From: Nicola Oktay on behalf of Planning.Responses
Sent: 20 November 2024 11:21
To: Planning Scanning
Subject: FW: R/196/24/CLP - 21 Mill Lane, Rustington - Lawful Development Certificate

In light of the application type, I believe that the factors below indicate that it is a material change of use and the application should go to planning instead of an LDC. I hope you will consider these factors and recommend that the application go to planning.

From: [REDACTED]
Sent: 13 November 2024 11:18
To: Rhiannon Lloyd <rhiannon.lloyd@arun.gov.uk>
Cc: Jodie Braham <[REDACTED]>
Subject: R/196/24/CLP - 21 Mill Lane, Rustington - Lawful Development Certificate

Drawn by : MISCHA
	Client : MR & MRS HUBBARD
	Drawing Title : PL PLAN
	Scale : 1:50 @ A3
	Date : 30 September 2024 14:34:11
Drawing Reference : 3500.24 - HTB- PLPL - OPT2B	
Revision Number : -

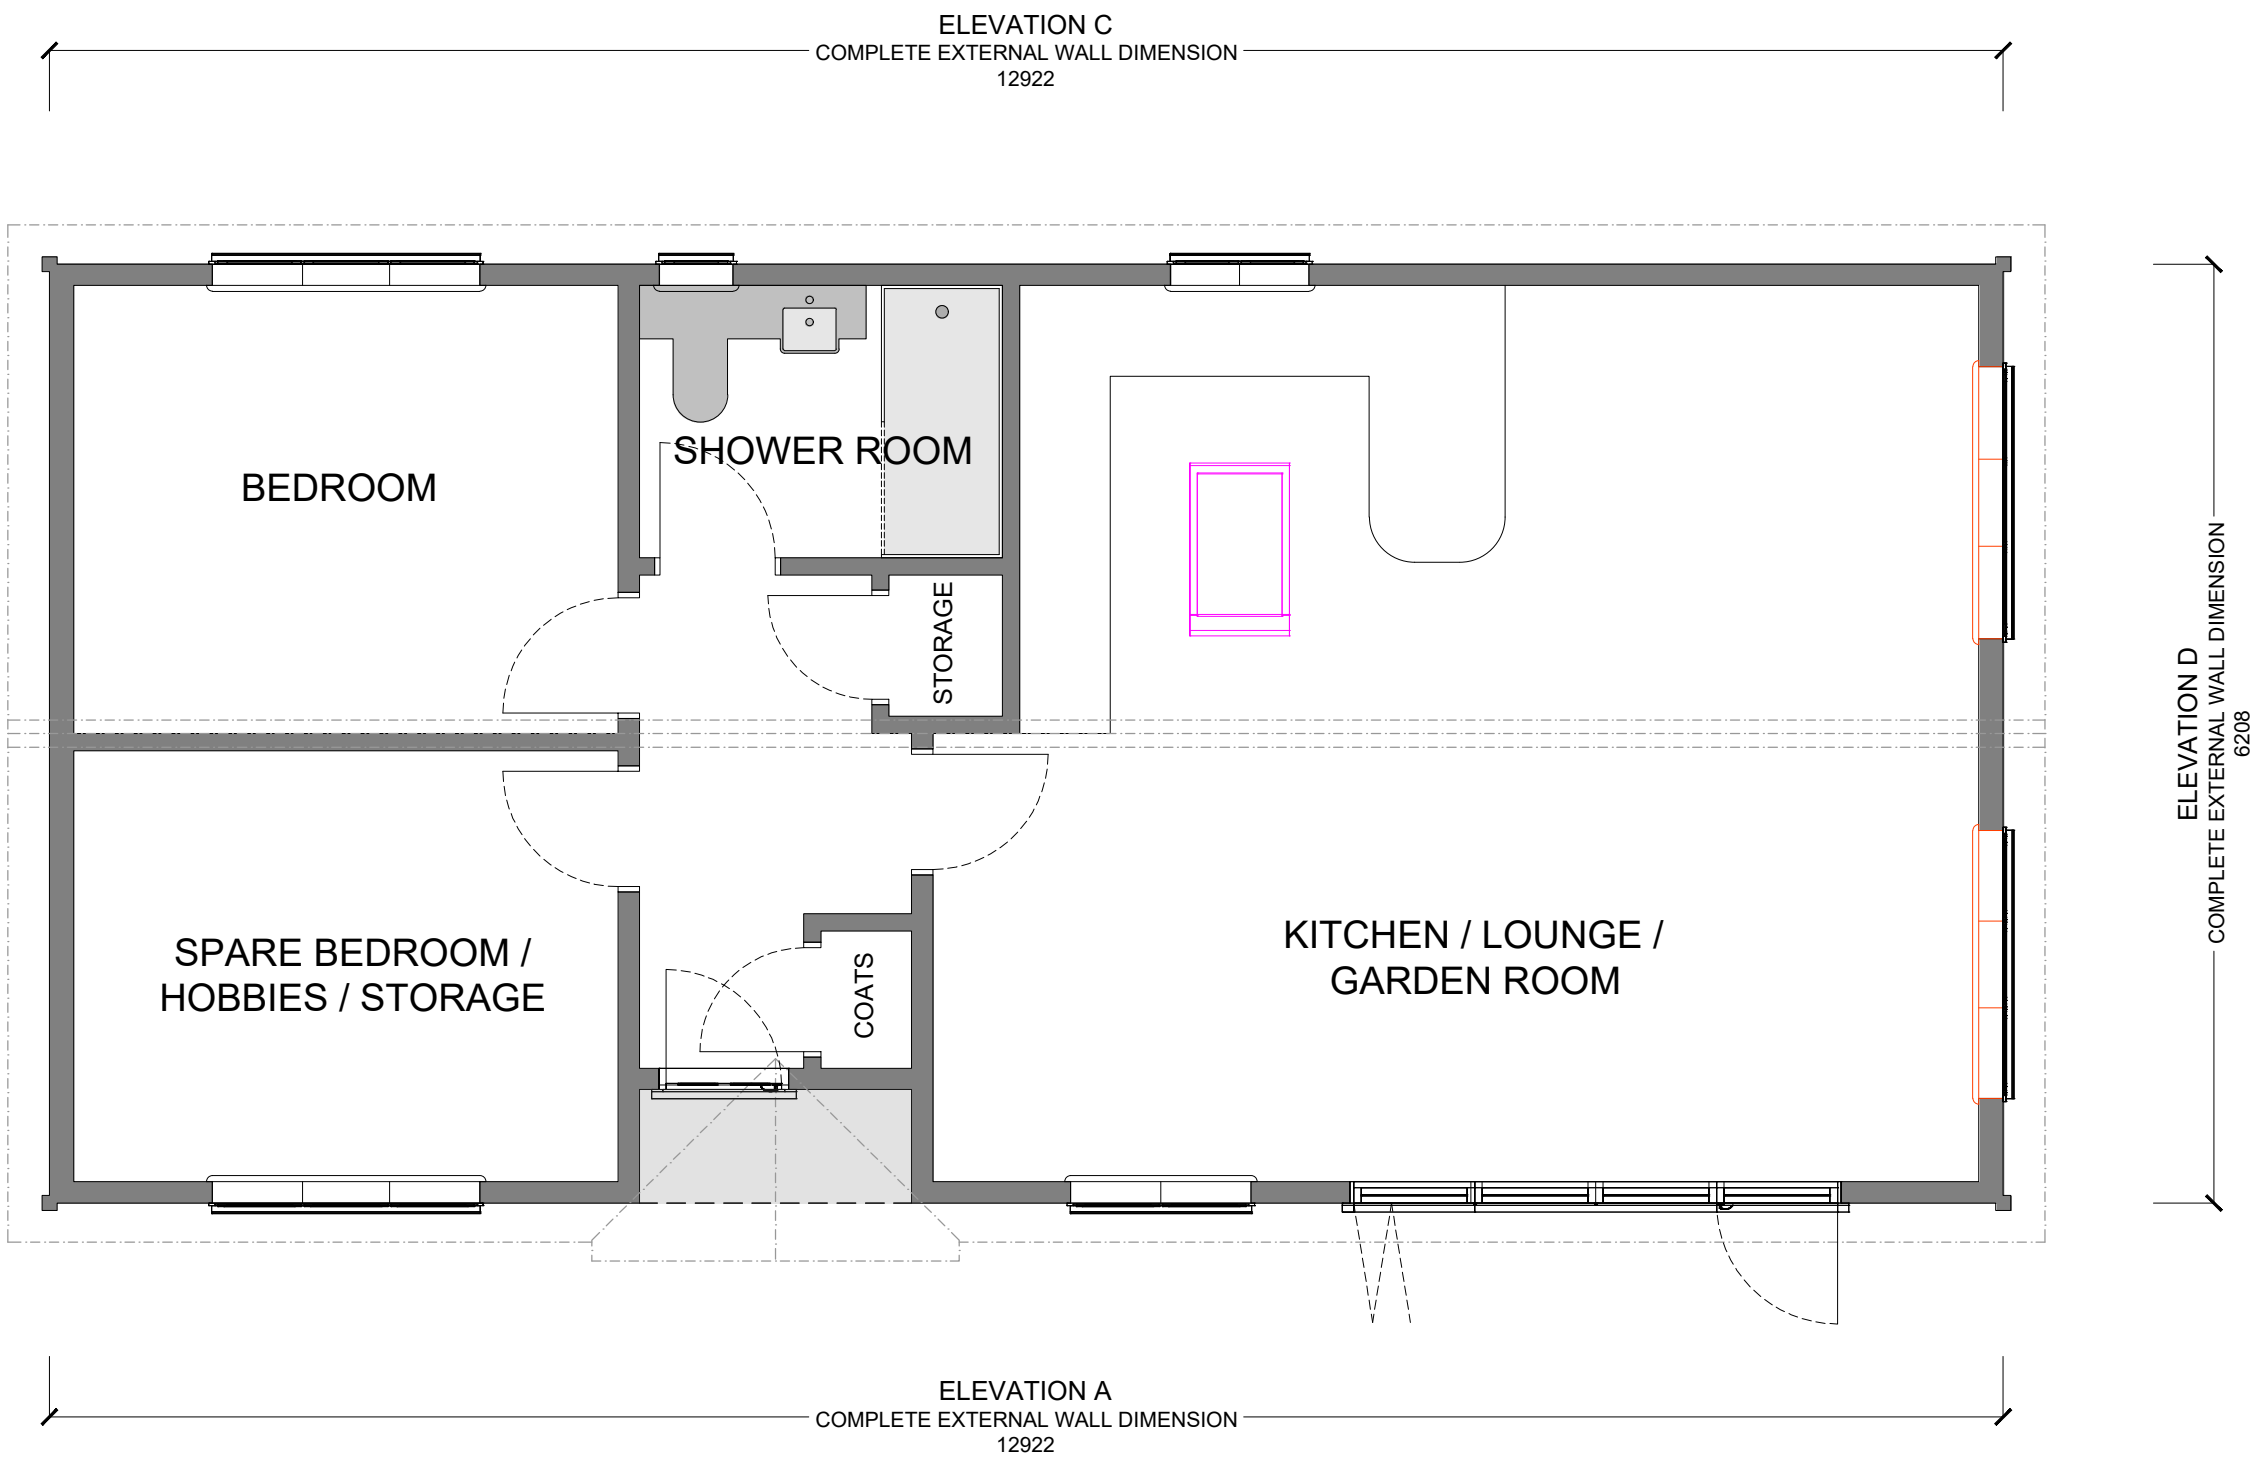
Proximity to the main dwelling: The mobile home caravan is positioned as far away as possible from the main dwelling (about 40m), making it difficult for family members and those residing in the mobile home, with reduced mobility, to gain access to the main dwelling conveniently. This remoteness will result in reduced care and support from family members residing in the main dwelling.

Privacy: The mobile home caravan is located in an area of the garden that will overlook neighbours on three sides. Two of the sides have windows directly facing neighbours. This does not maintain the privacy of the residential setting and does not take into consideration neighbours' privacy.

Drawn by :
MISCHA
Client :
MR & MRS HUBBARD
Drawing Title :
PL ELEVATION C-D
Scale :
1:50 @ A3
Date :
30 September 2024 14:34:11
Drawing Reference :
3500.24 - HTB- PLEL - OPT2B
Revision Number : -

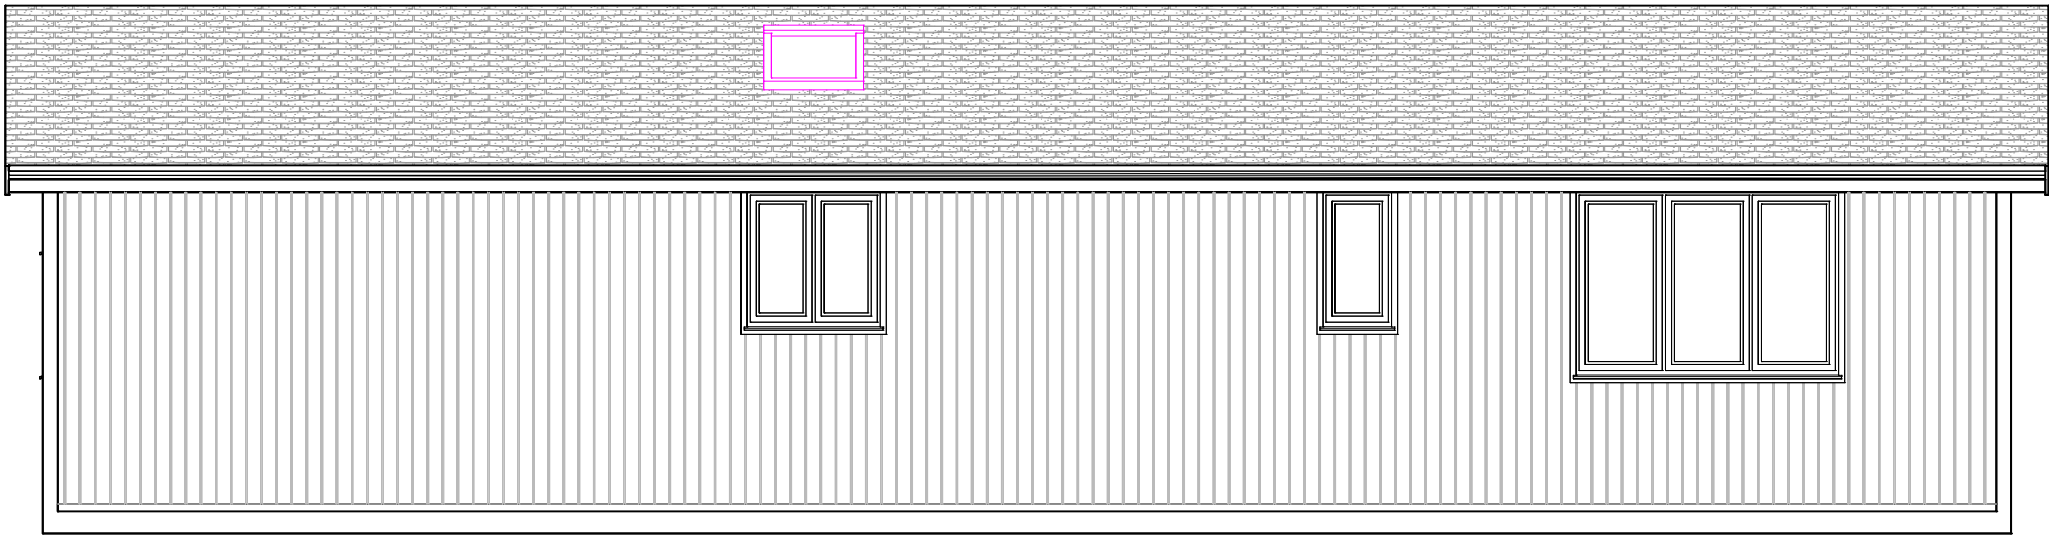
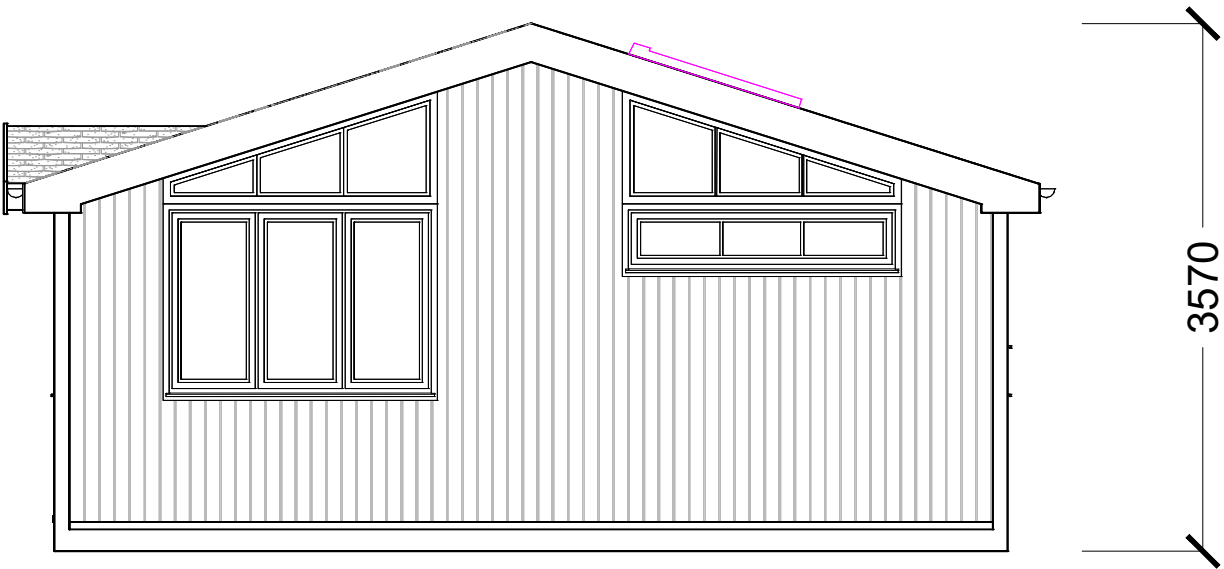
Visual impact: The chosen location of the mobile home caravan has a large visual impact on the surrounding area and neighbouring properties. The proximity of 1m or less to each boundary and the height of at least 3.57m is far higher than the boundary fences surrounding it. There is no space for screening on the property because of the closeness to the boundary, which places the burden on neighbours to perform the screening themselves on their own properties, to reduce the visual impact. There is a high visual impact and the look and feel of the neighbourhood will change from within neighbours' private gardens.

From the plans, the mobile home will be 1m from our boundary and 3.57m high and will face back towards the rear of our dwelling. We are concerned about being overlooked and also having light pollution in the rear garden and hope that the Council would consider adding provisions to alleviate these concerns:

Therefore, effect on neighbours is not formally considered when assessing this type of application, as per the legislation.
